About the application

Application number: 2023/91280	
What is the application for?:	Quarrying operations for the extraction of clay, shale and incidental coal and s
Address of the site or building:	Bromley Farm Quarry, Barnsley Road, Upper Cumberworth, Huddersfield, HD8 8PD
Postcode:	S36 4HG

User comments

Type of comment: An objection	
Do you wish your comments to be published on the website anonymously?	Yes

APPENDIX B
SoundPlan Noise Contour Plans

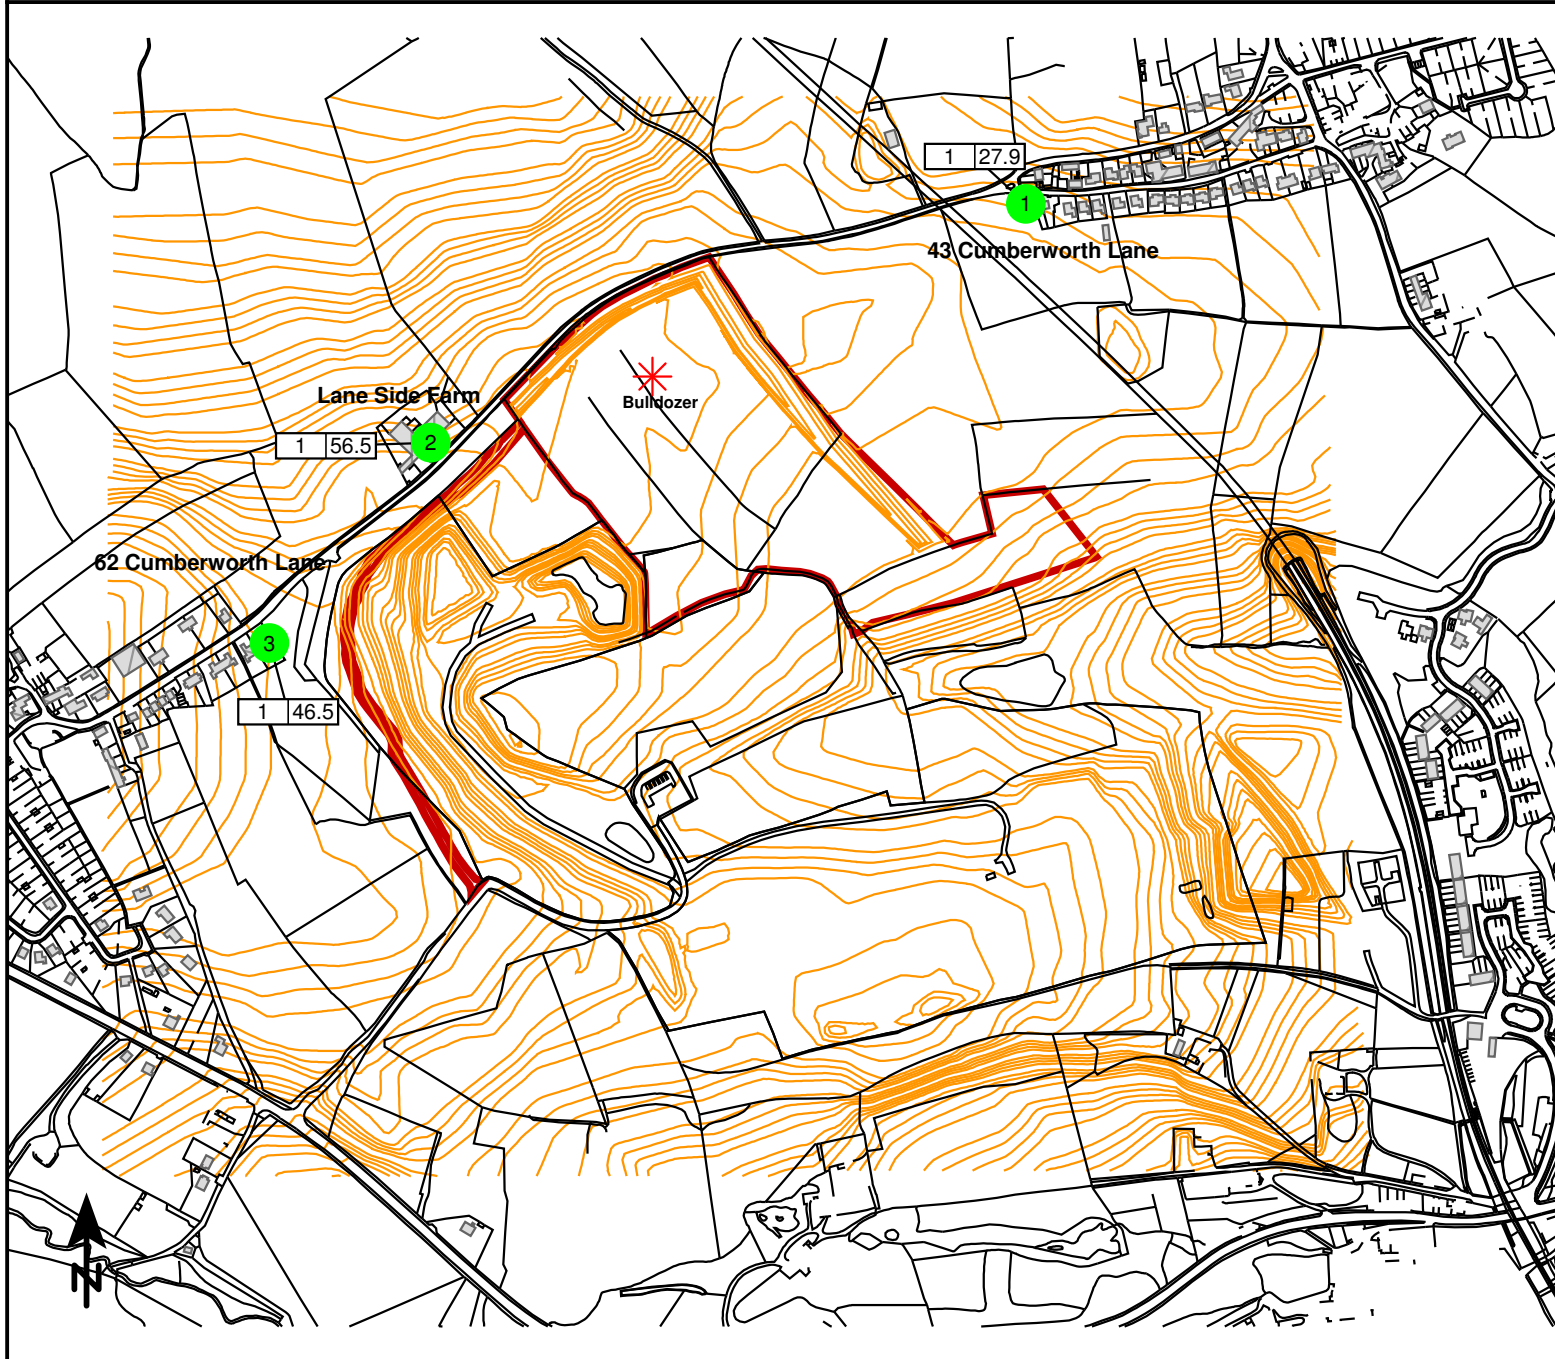
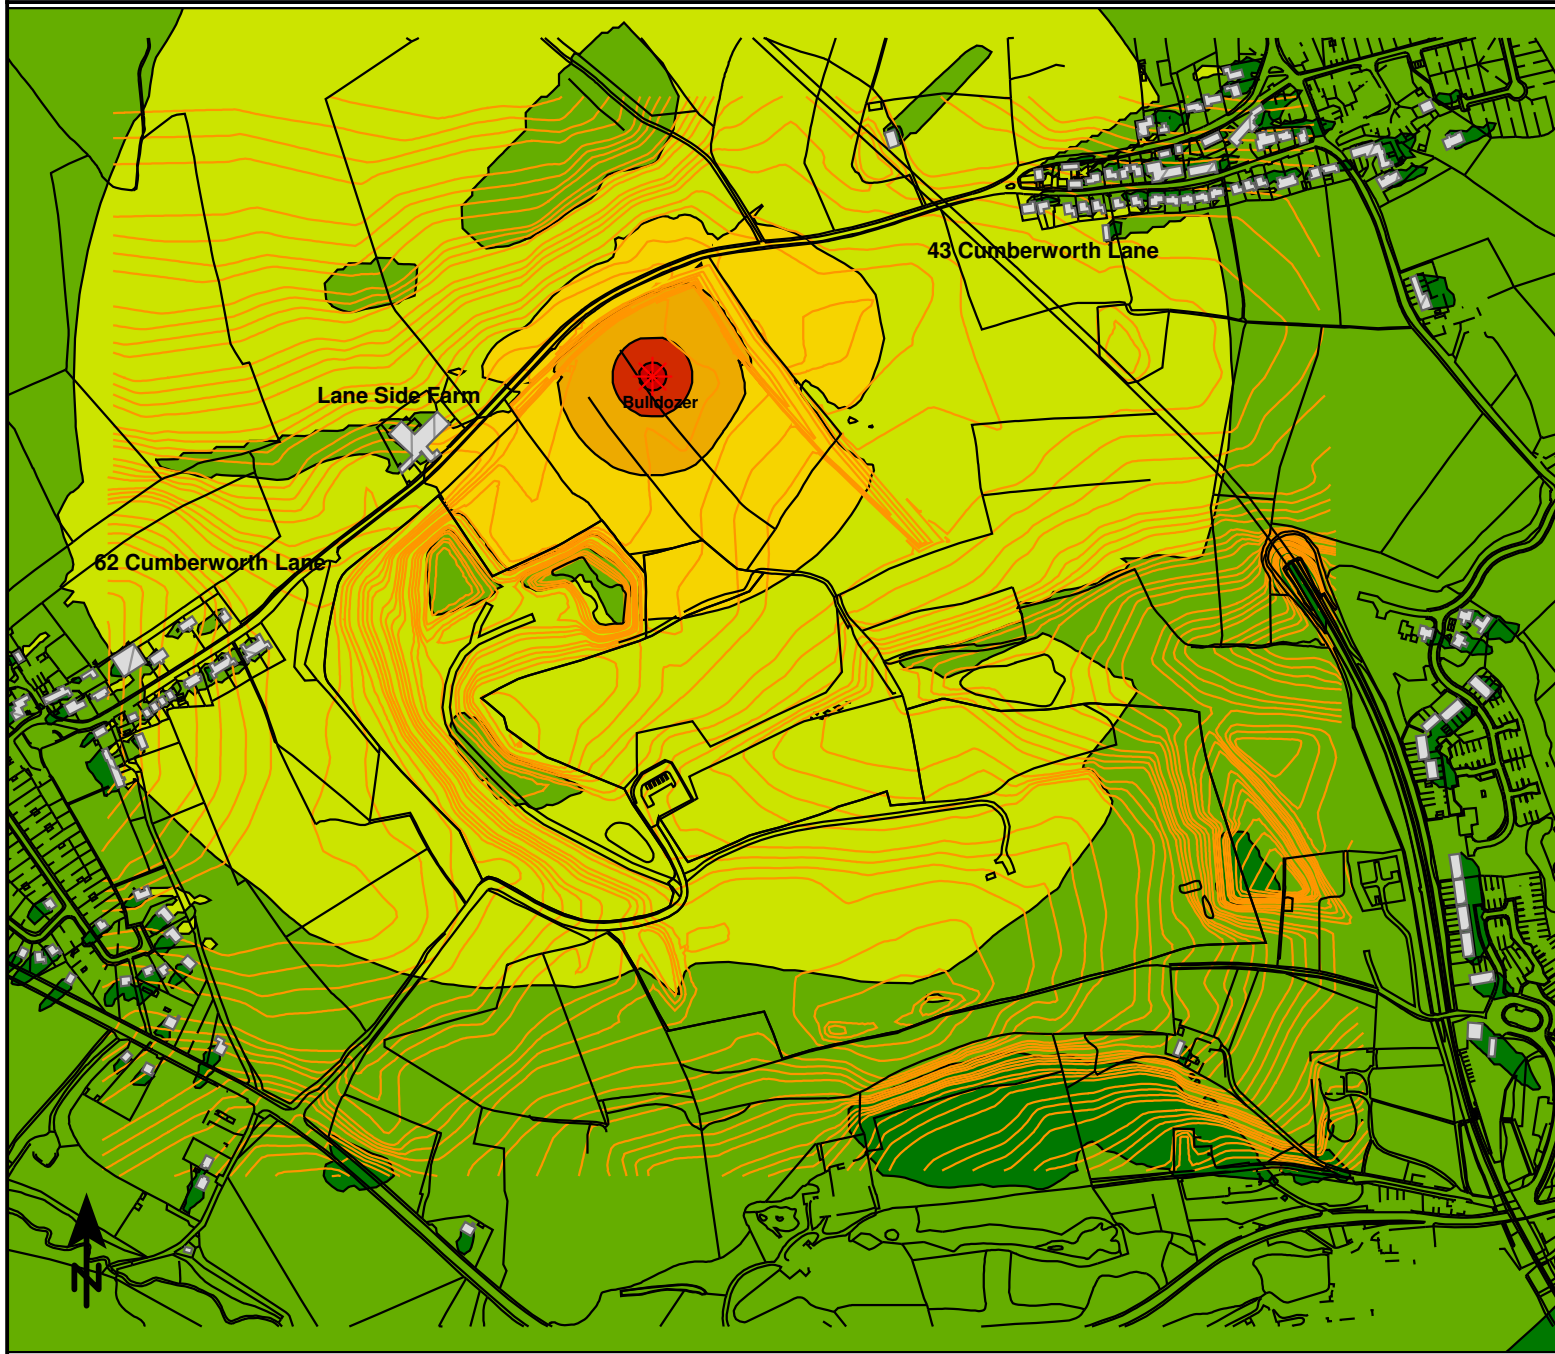
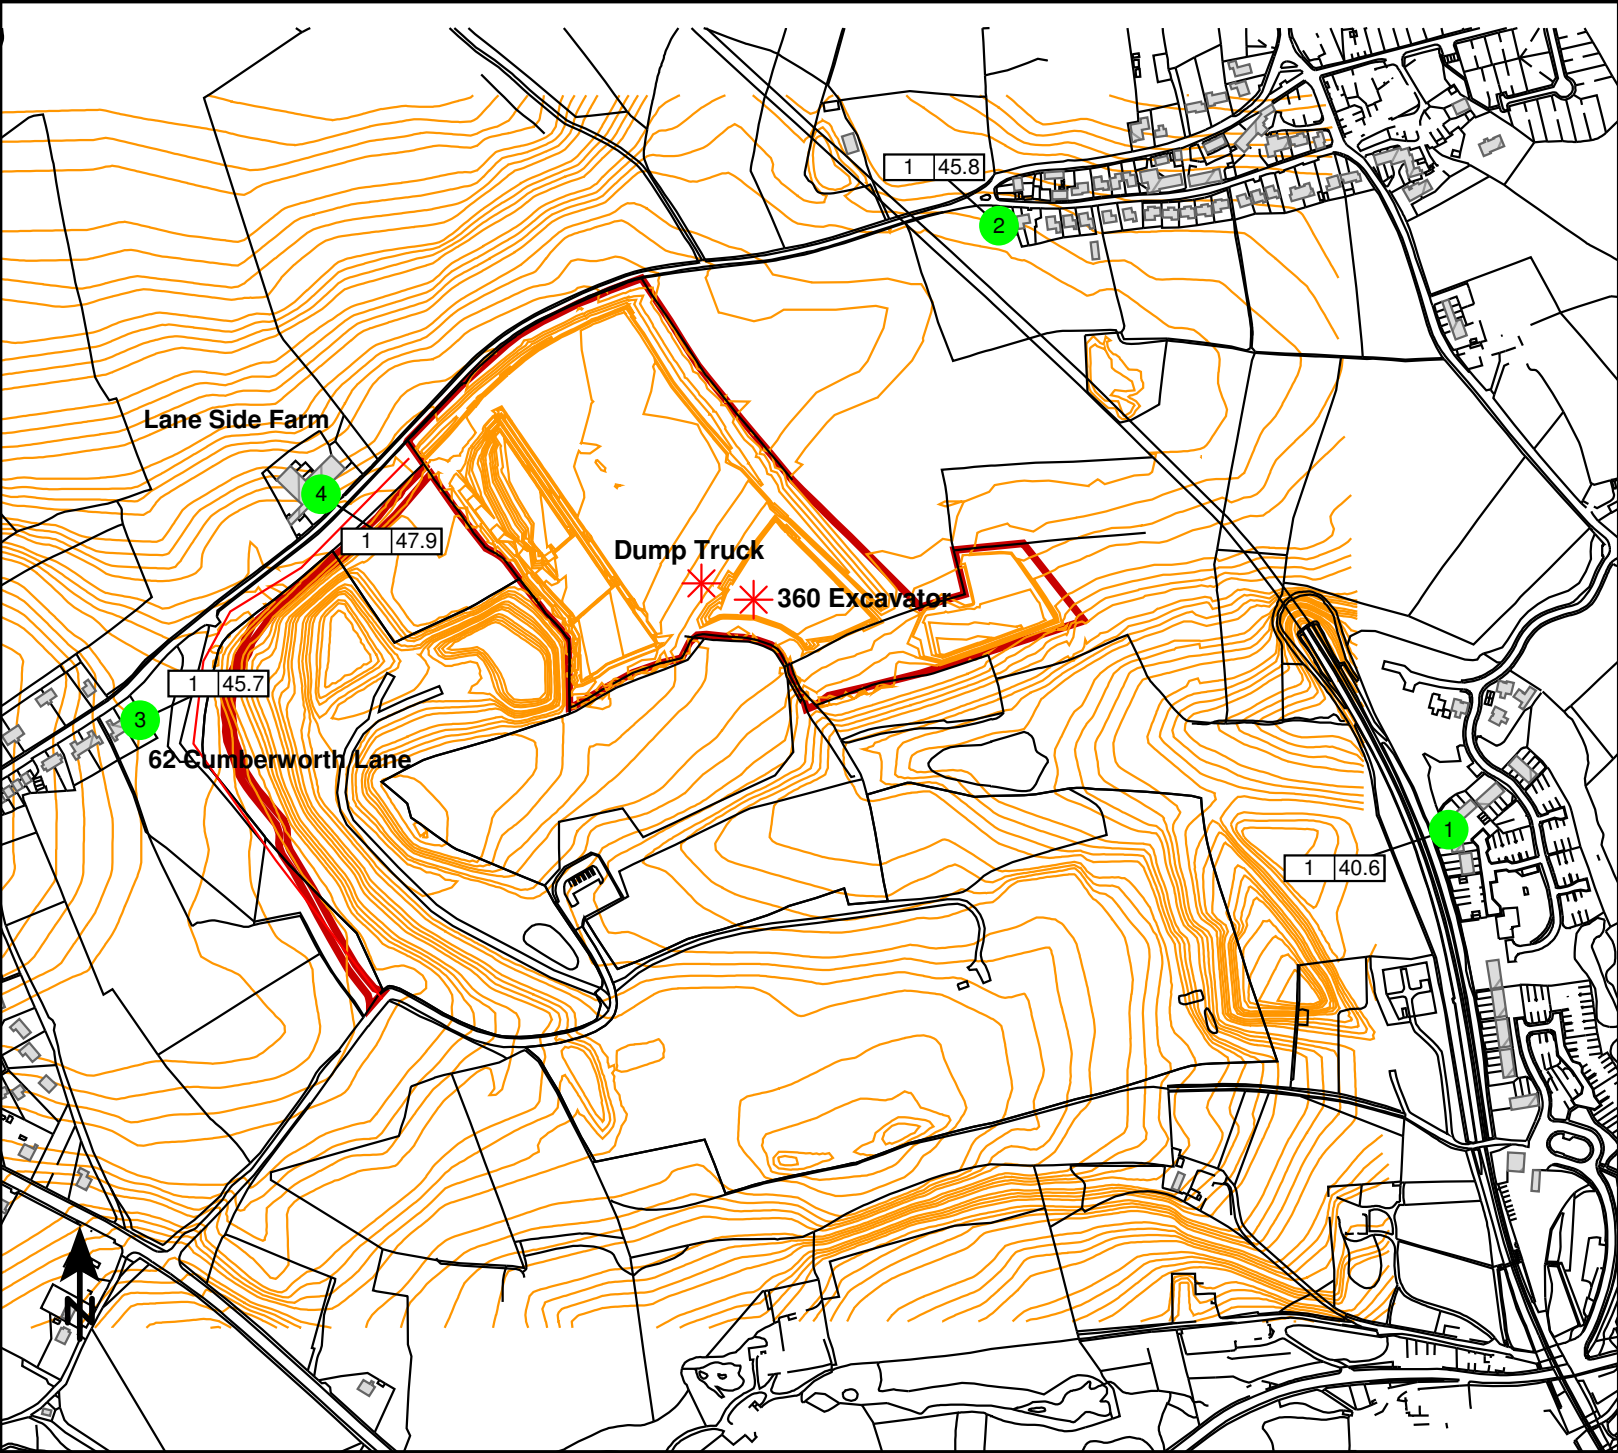
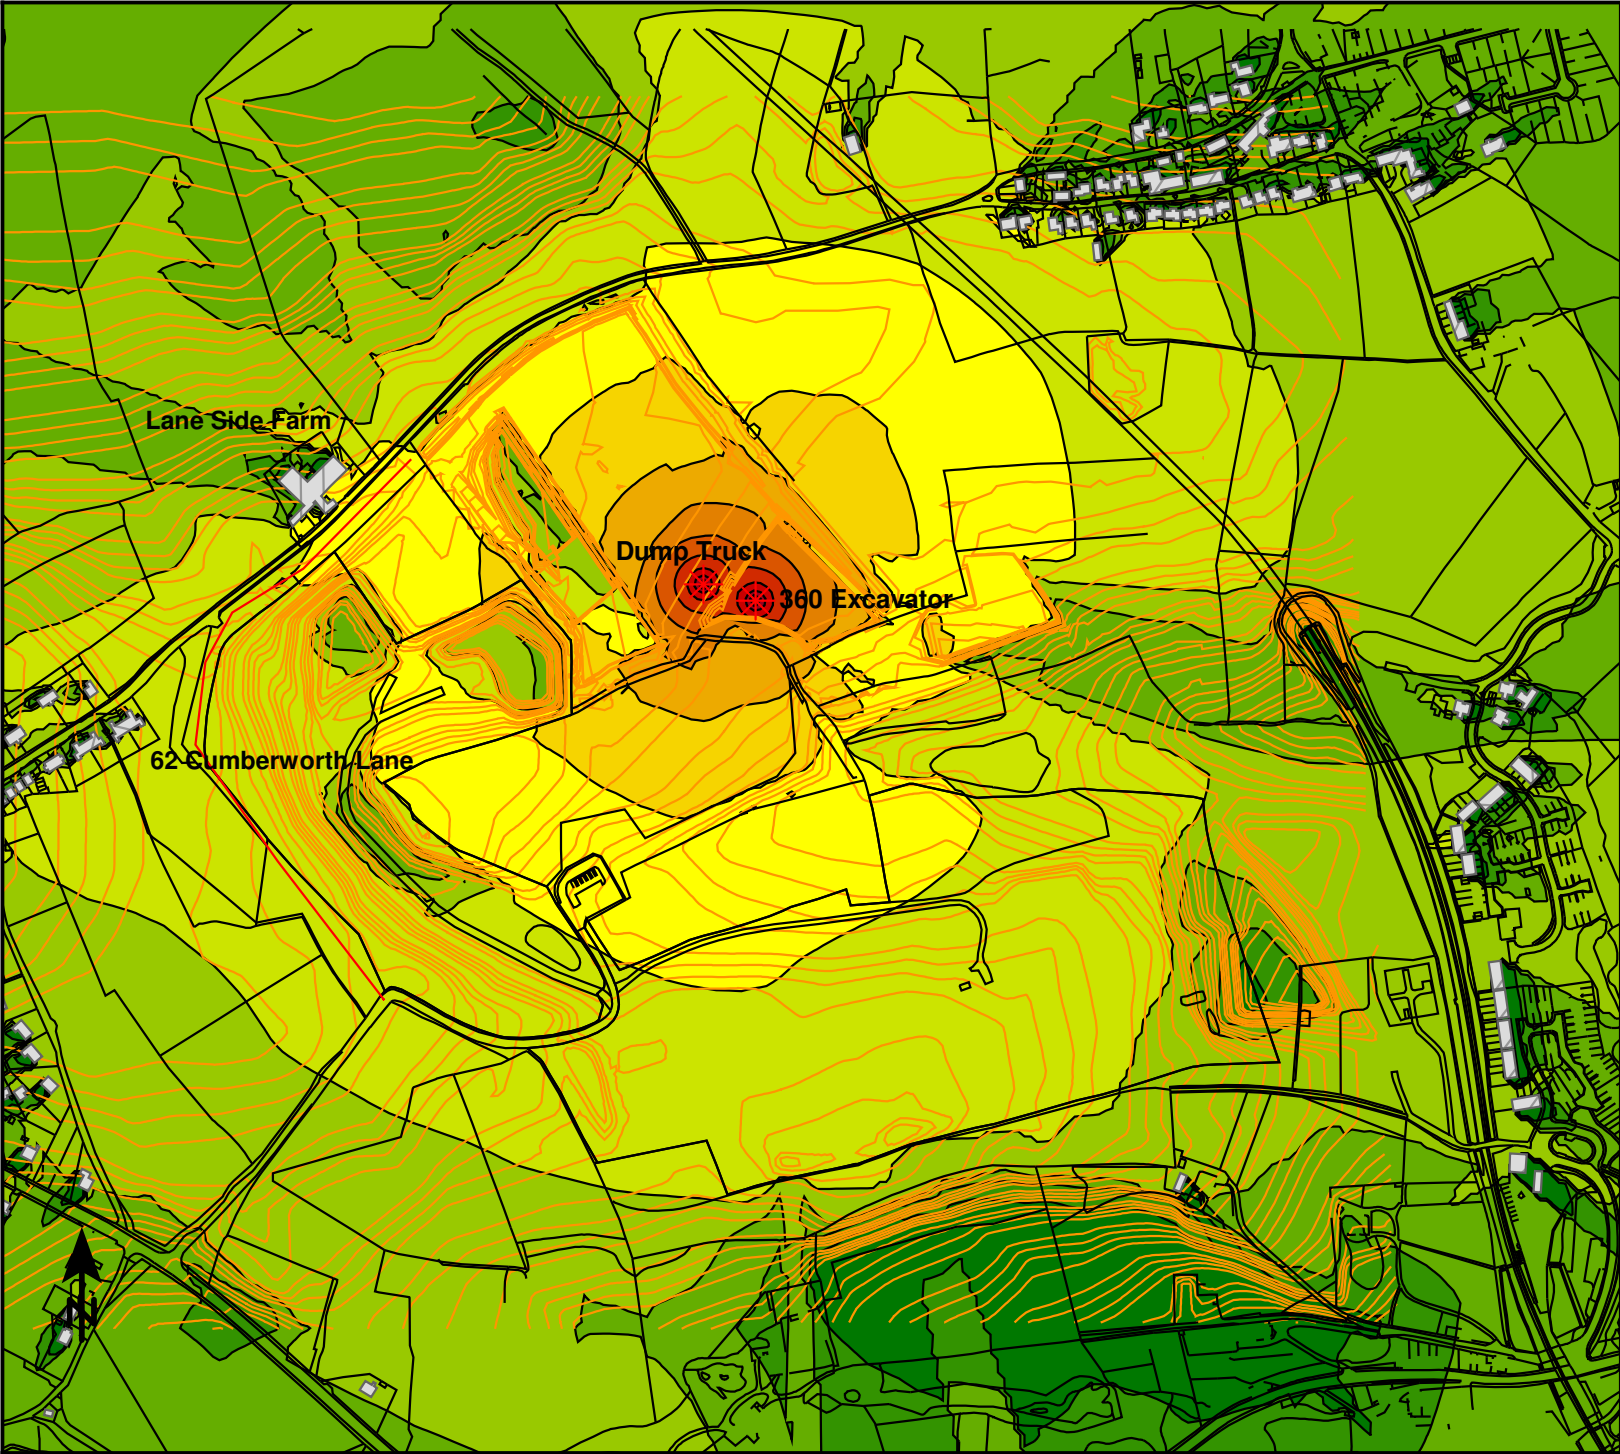
The assessment focusses on the three closest properties, but fails to draw attention to the other affected properties as shown in the drawings at the back of the report. This needs to be highlighted to the residents of Upper Cumberworth in a fair way, not buried in a report appendix.

NPPF technical guidance criteria of no more than 10dB change above background noise where possible, is exceeded in every modelled scenario (even with the poor baseline dataset), not just at the three closest properties but also across large residential areas of Upper Cumberworth. The application fails to draw attention to this, and in every case leans on the criteria for a maximum of 55dB being passable in cases where the 10dB change cannot be complied with.

The increase in noise over the working periods and timeframe is significant and detrimental to the mental well-being of the residents of Cumberworth. People live here for its rural, peaceful character, and wellbeing. Anyone in the impacted zones shown on the maps will hear the quarry activity constantly.
